**Subject: DEVIATION REVIEW AND DECISION FORM**

Subdivision or Project Name: Winsome

Section of ECM from Which Deviation is Sought: Section 2.8.8.A. cul-de-sacs

Proposed Nature and Extent of Deviation: The standard maximum dead end length for cul-de-sacs is 1,600'. The proposed interim dead end length of Alamar Way is approximately 4,650'.

PHASING PLAN

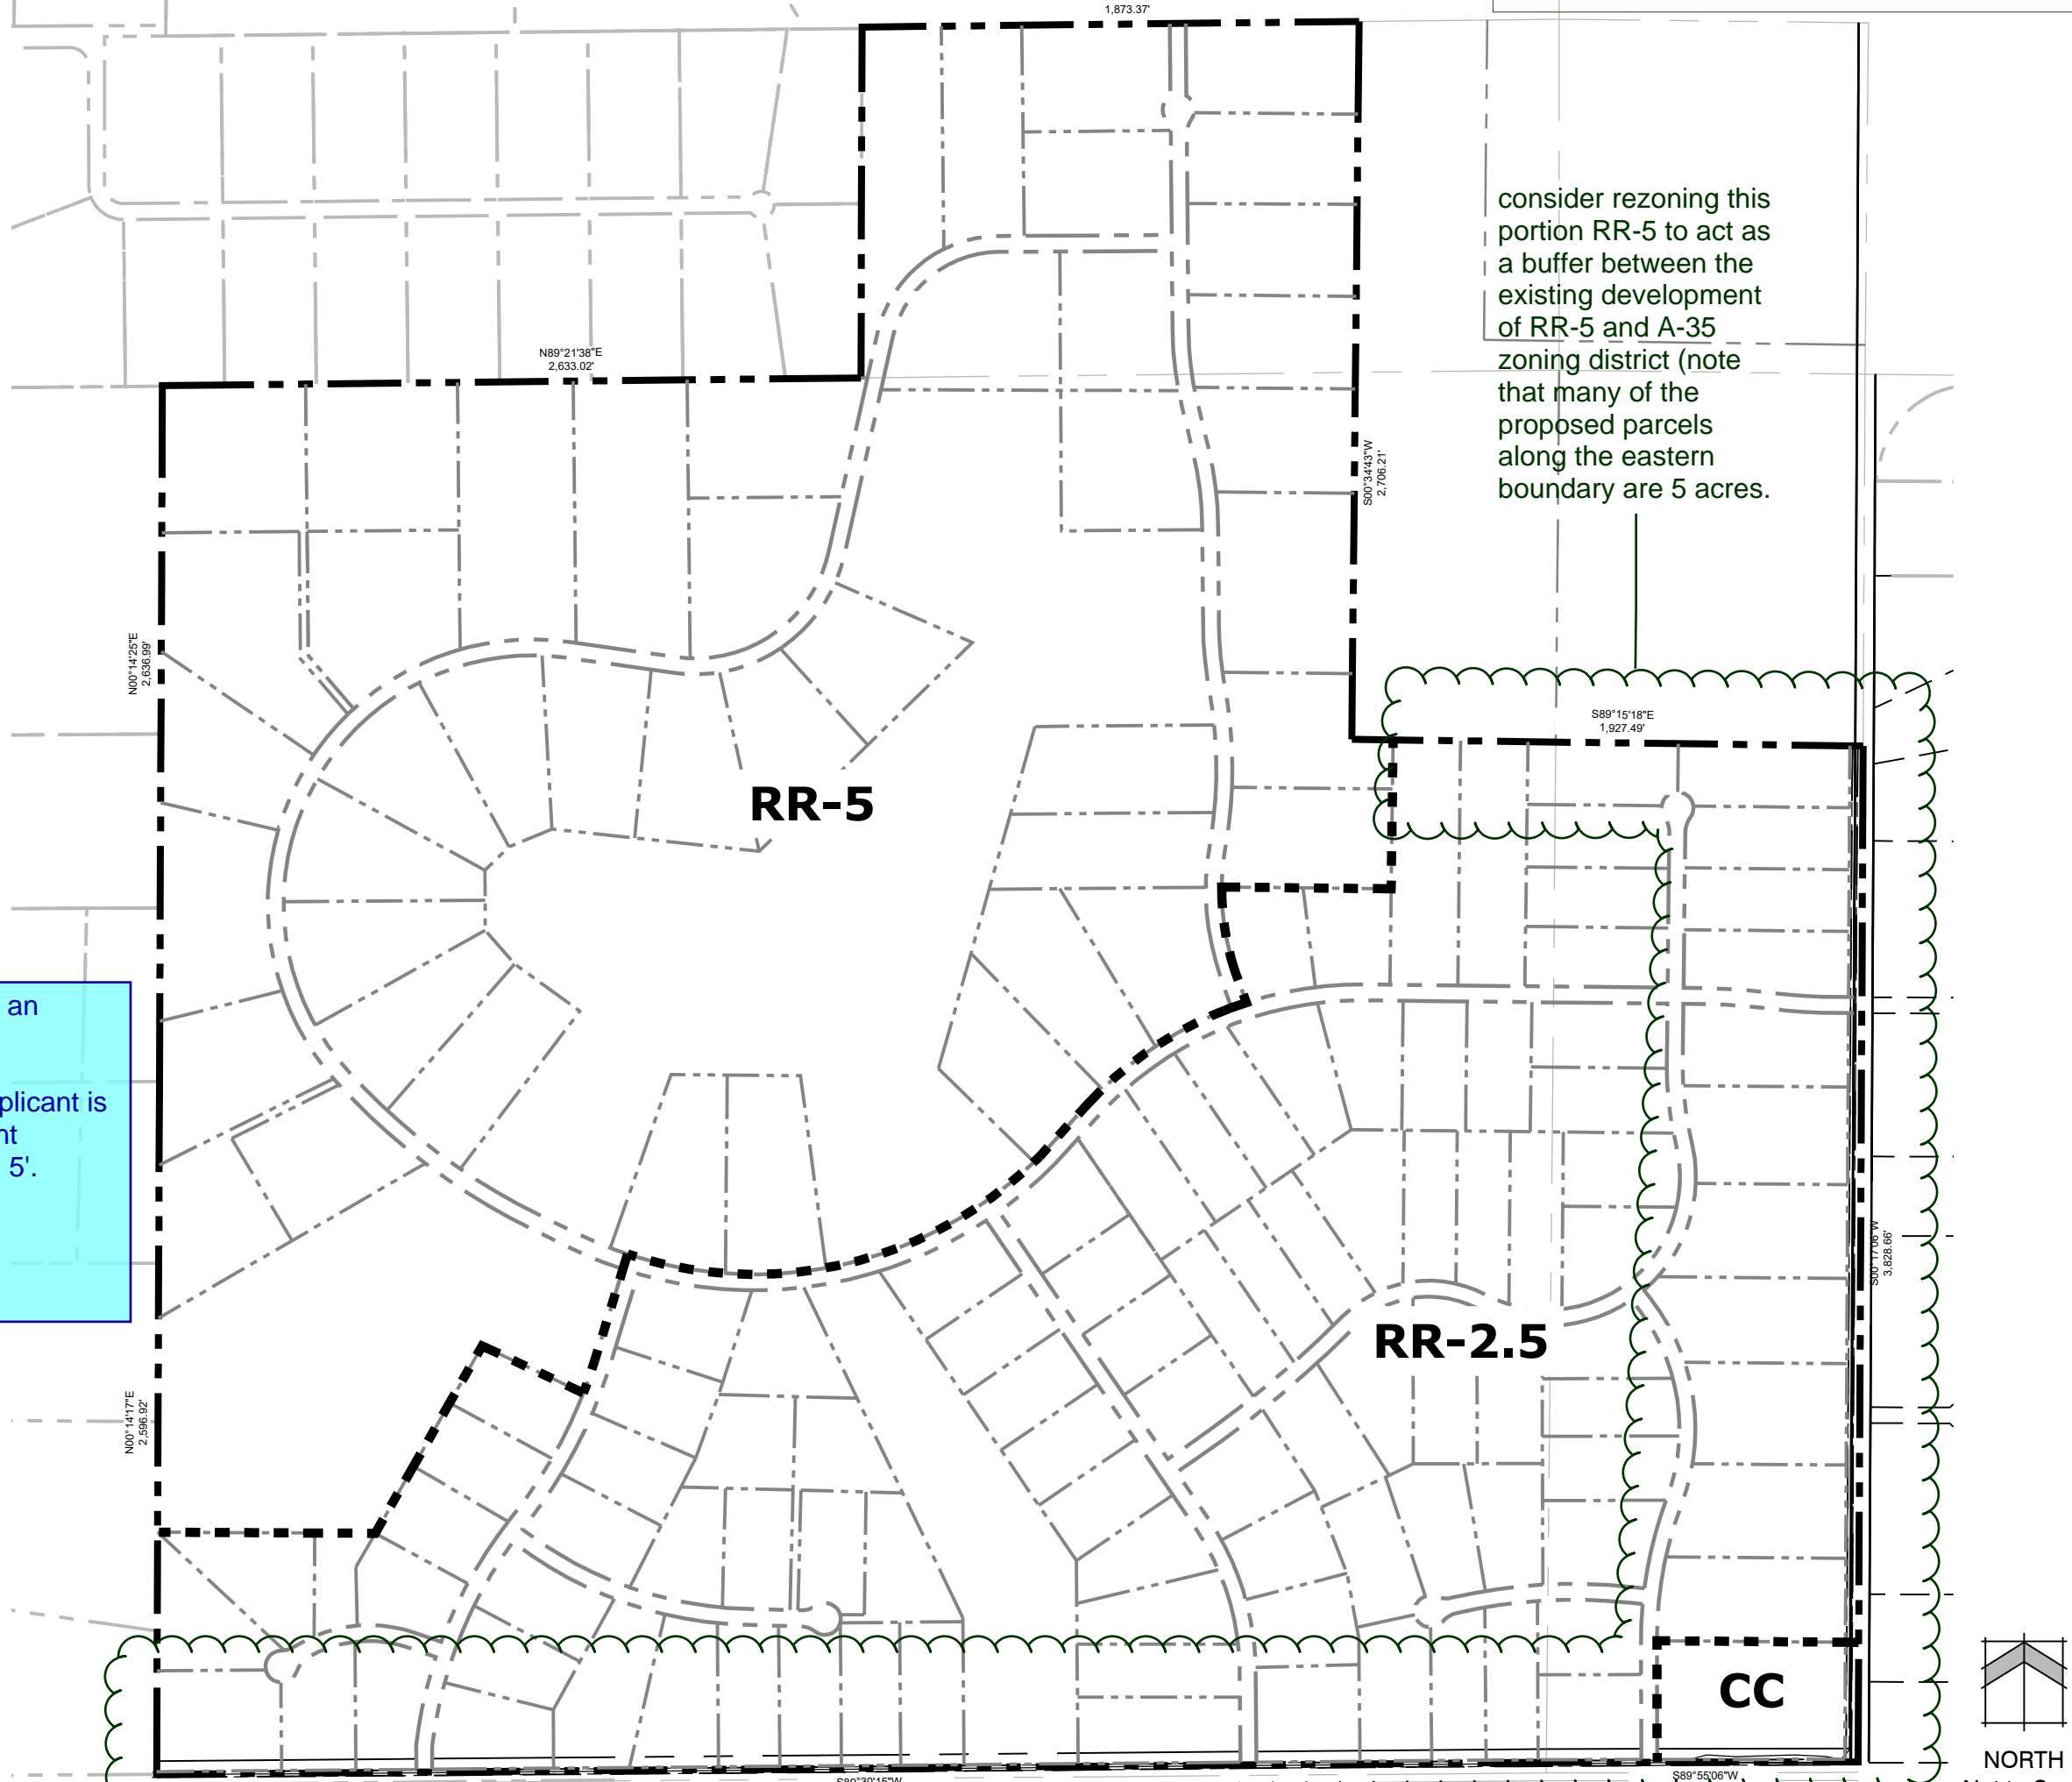
Attach a written endorsement from the Fire District. Per ECM 2.3.8.A deviation request from the maximum length criteria will not be considered without an express written endorsement from the Fire District.

Note on the deviation request that a temporary cul-de-sac will be constructed.

Label the street and phasing this applies to.
